Lake Hume Battery Energy Storage System
Application No: SSD-10460

I am writing to your office in relation to the application for the installation of a Battery Energy Storage System at Lake Hume.

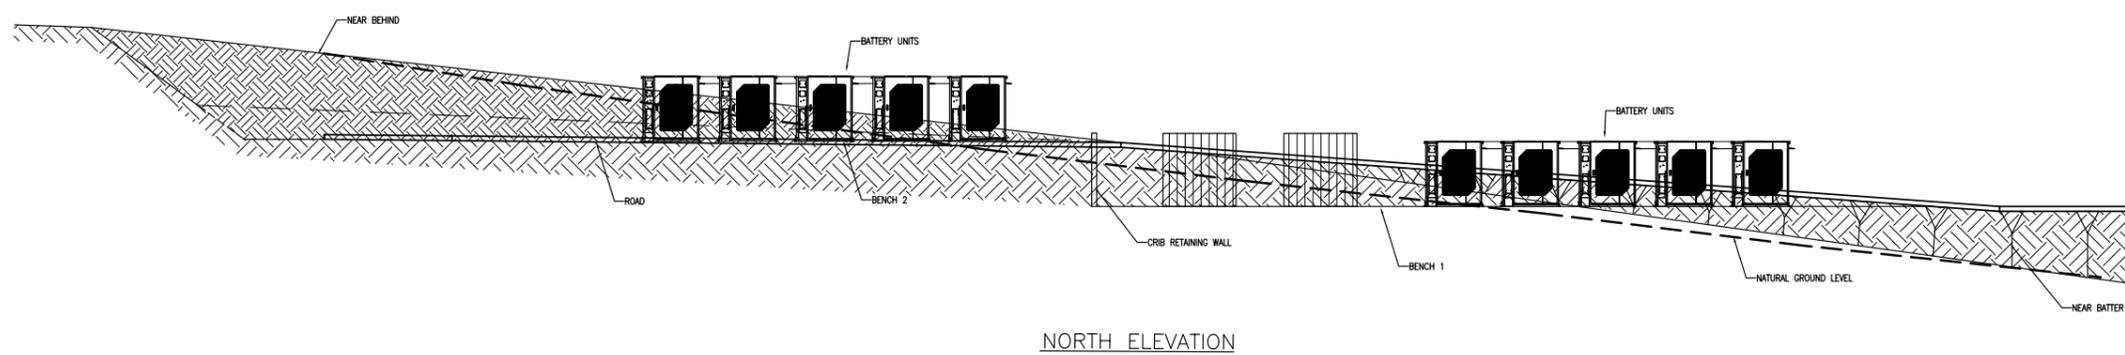
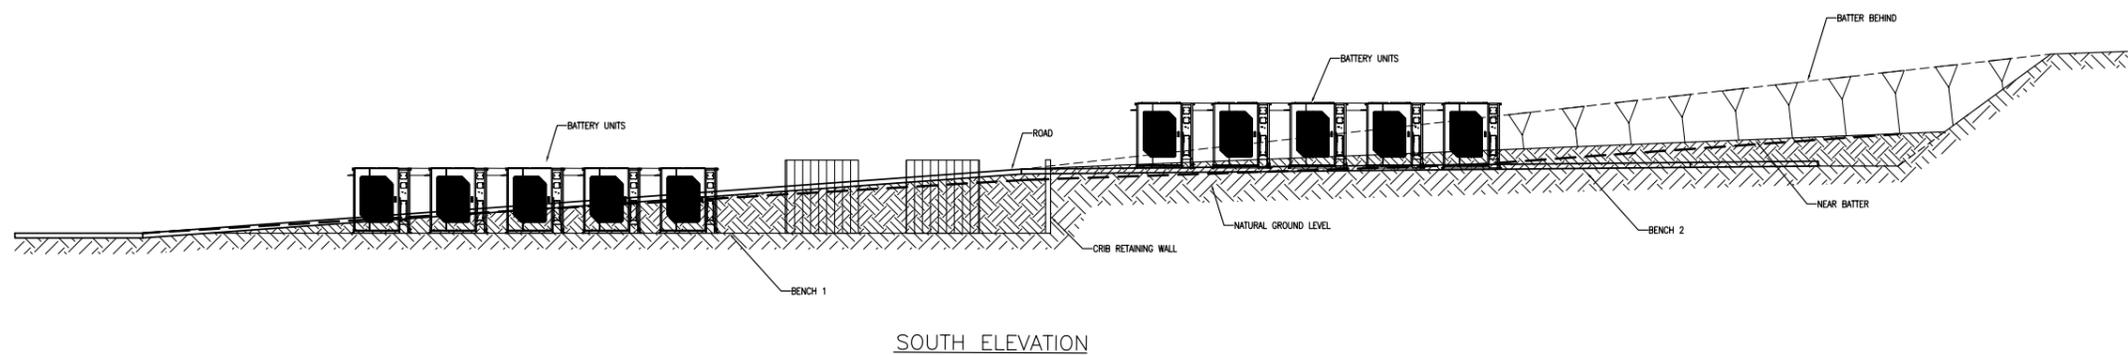
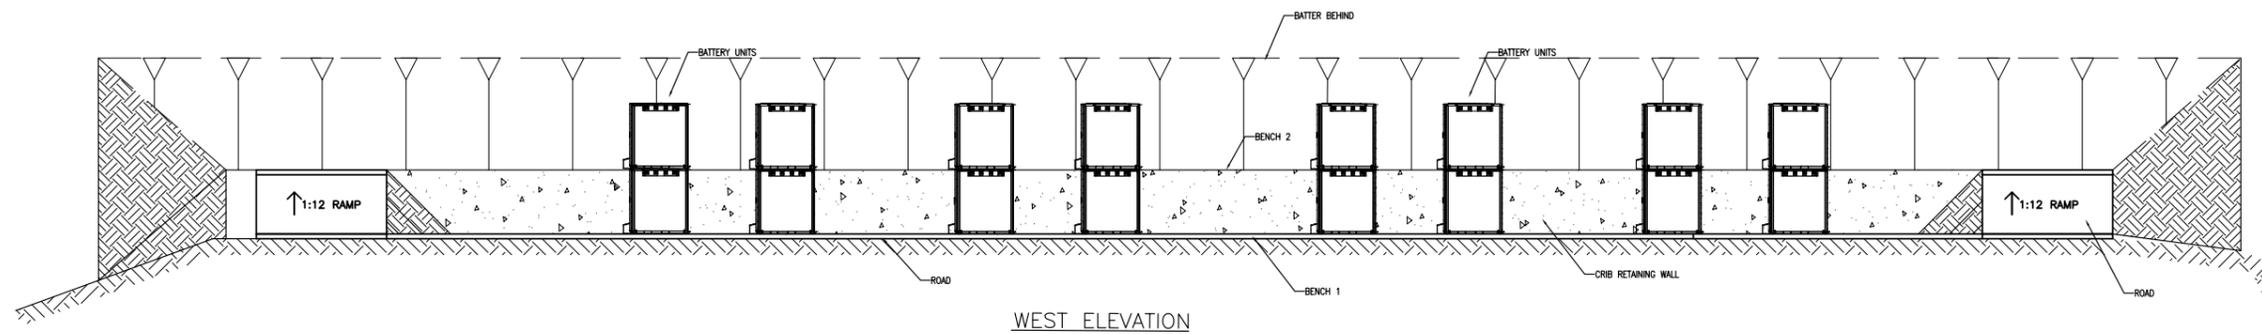
- adjust the BESS siting, and lower the BESS base level, to ensure Pod's rooflines, on the side facing the Trout Farm Road (east elevation?), are below excavation levels (by approx. 0.25 to 0.5 m),
- Construct bun walls, or solid concrete barriers, around the BESS Pad base area. Essential for the side facing the Trout Farm Rd (east elevation?), to have solid protection for sound, fire and possible explosion, to a height of approx. 0.25 to 0.5 m above the top of the height of all BESS pods,
- fencing type and location to be glider friendly,
- monitoring of gliders to confirm population numbers,
- sympathetic natural screening to ensure BESS is largely not visible from the Trout Farm Road or adjacent properties,
- an independent Authority to oversee sound monitoring (eg EPA).

Figure 6-4 Predicted operational noise levels $L_{Aeq\ 15\ minute}$ dB(A), worst-case meteorological conditions

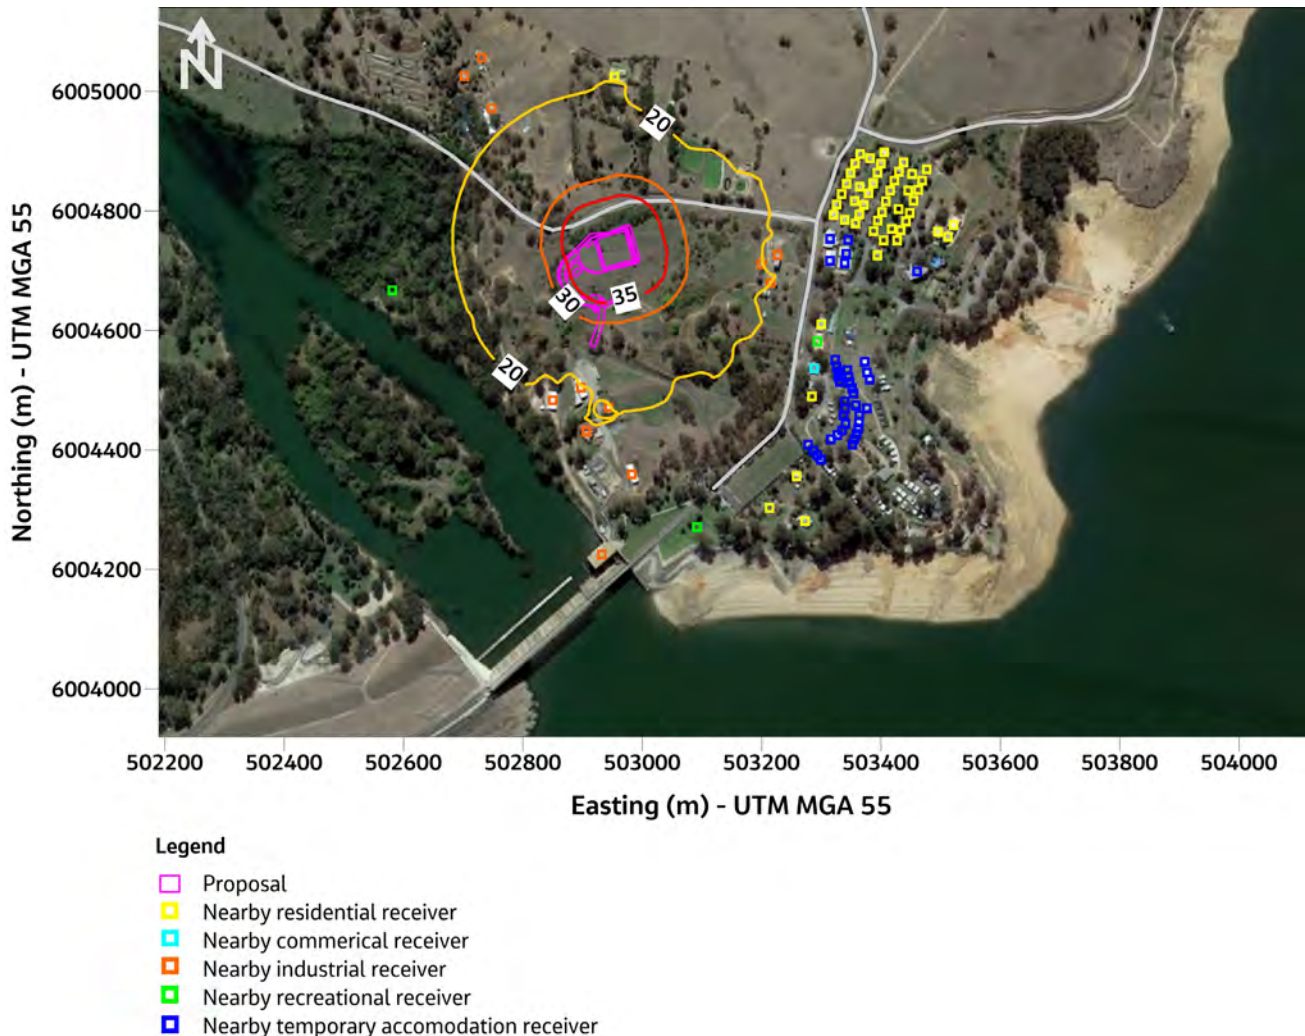
Noise/vibration	<p>One of the wonderful things about our property is the general quietness and the sounds of nature. The sounds of the Ibis rookery near the River, the frogs in the pond, the tweet of wrens and parrots, the sounds of the River and water from the Dam valve or the power station.</p> <p>Noise is assessed for our property at the receiver point RR01, the nearest residence to the proposed site. However, we are retired and spend the majority of the day time hours working around our property. For example, we walk the dog around the boundaries daily or more. We often eat outside and entertain visiting family and friends outside, regularly as “picnics” enjoying the property’s magnificent views and sounds.</p> <p>Noise estimates provided at our home (RR01) during construction are 57 dB(A), 12 dB(A) above the NML, rated moderately intrusive (EIS, p 83).</p> <p>EIS sound Figures 6.1 to 6.3, show noise estimates of:</p> <ul style="list-style-type: none"> • 65 dB (A), 20 dB(A) above the NML in our the middle “Snow View “paddock, and • 75 dB(A), 30 dB(A) above the NML in our entrance/front “Mailbox Paddock (interpreted from Appendix H, pp 16-18). <p>We have <u>major concerns</u> about noise and vibration generated by excavation of rock, “drilling rig” and other equipment used and methods. Borehole investigations found Granite rock at 0.7m m-1.7m (Section 14.2.3 Soils, p 99). Evidence of the shallow hard rock can be seen in Figure 11.2, Photo VP 04 (EIS, p 79).</p> <p>We are concerned excavation of this rock will involve:</p> <ul style="list-style-type: none"> • drilling/blasting • need for a percussion hammer to get through the approximately 1.3 m - 2.3 m of rock. <p>Our teleconference with the Meridian BESS Project Team revealed that a piling driver may also be involved to place BESS pods on site. These general short impact noises are not accounted for in the noise estimates.</p> <p>The adoption of the Northern location maximises the adverse noise impacts on our residential dwelling (RR01) and other Trout Farm Road</p>

Figure 4-2 Key environmental constraints

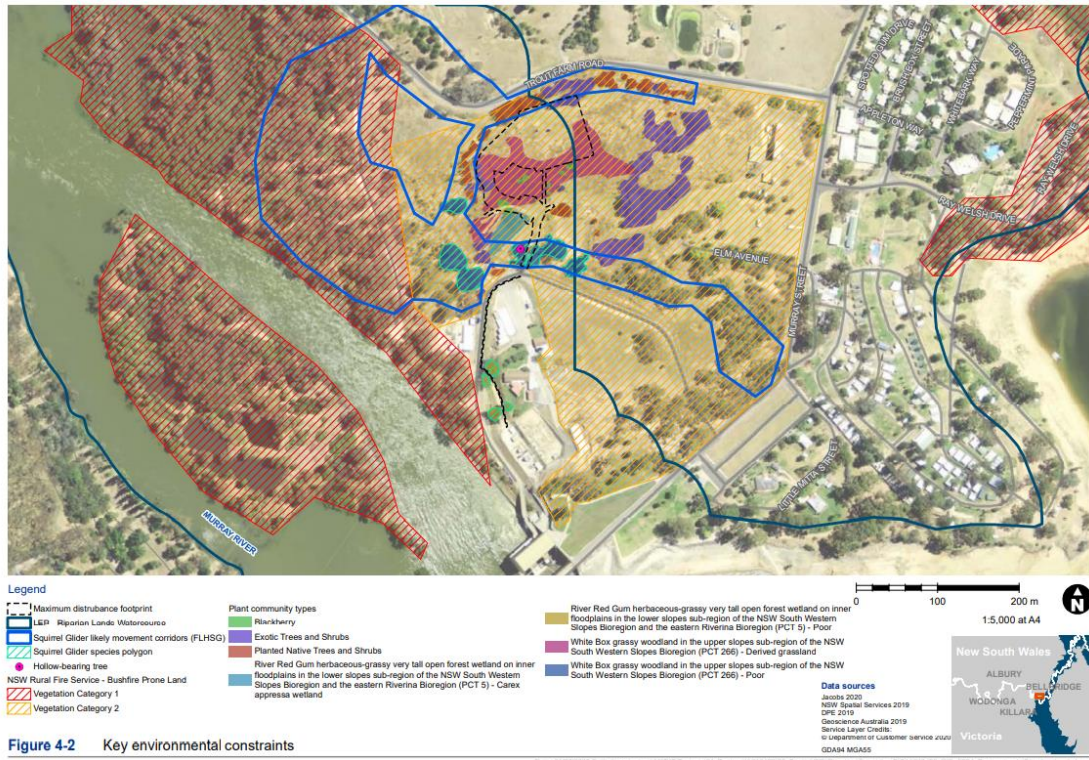
Requirement	Comment
<p>A detailed constraints map identifying the key environmental and other land use constraints that have informed the final design of the development;</p>	<p>No single map is provided. A figure showing “Key environmental constraints” is provided in the EIS (Figure 4.2, p38). This solely addresses vegetation communities and squirrel glider activity. Another map, “Fig 4.1 Surrounding land use”, only shows residences and buildings, powerlines and LEP Planning Zones. No map information is presented identifying the key constraints nominated to have determined the site selection; <i>... subterranean infrastructure and unfavourable topography.</i></p> <p>The information presented is largely descriptive. With the exception of Heritage and Biodiversity, it is vague or at an inappropriate scale. For example, <i>.... are constrained by the presence of transmission easements, subterranean infrastructure, existing operational uses, unfavourable topography or at elevated risk of containing items of heritage significance</i> (EIS, p 36, Para 2). Transmission easements - Figure 1.1 in the Scoping Report clearly shows both the Southern and Northern locations outside the transmission line easement. Subterranean infrastructure –not described in detailed or shown on maps in the EIS material. Where is it? Is active or redundant? If active, could it easily be relocated? Unfavourable topography - not described in detailed or shown on maps in the EIS material. What are the actual constraints? Can they be worked around with a modified design?</p> <p>Only a few sentences are presented regarding the geology, landform and soils of the location options. The data sources are very course and are not of an appropriate local scale. Landform and soil information is interpreted from the 1:100,000 scale DPIE Soil Landscape mapping (1 cm on map equal 1 km on the ground). The geology information referenced, but not listed in the bibliography, is highly likely to be 1:250,000 scale mapping (1 cm on map equal 2.5 km on the ground).</p> <p>Necessary information such as site engineering properties is not provided for the two location options, just the Northern location. Although described and referenced, the bore log investigation results are not presented in the EIS or Appendices.</p>
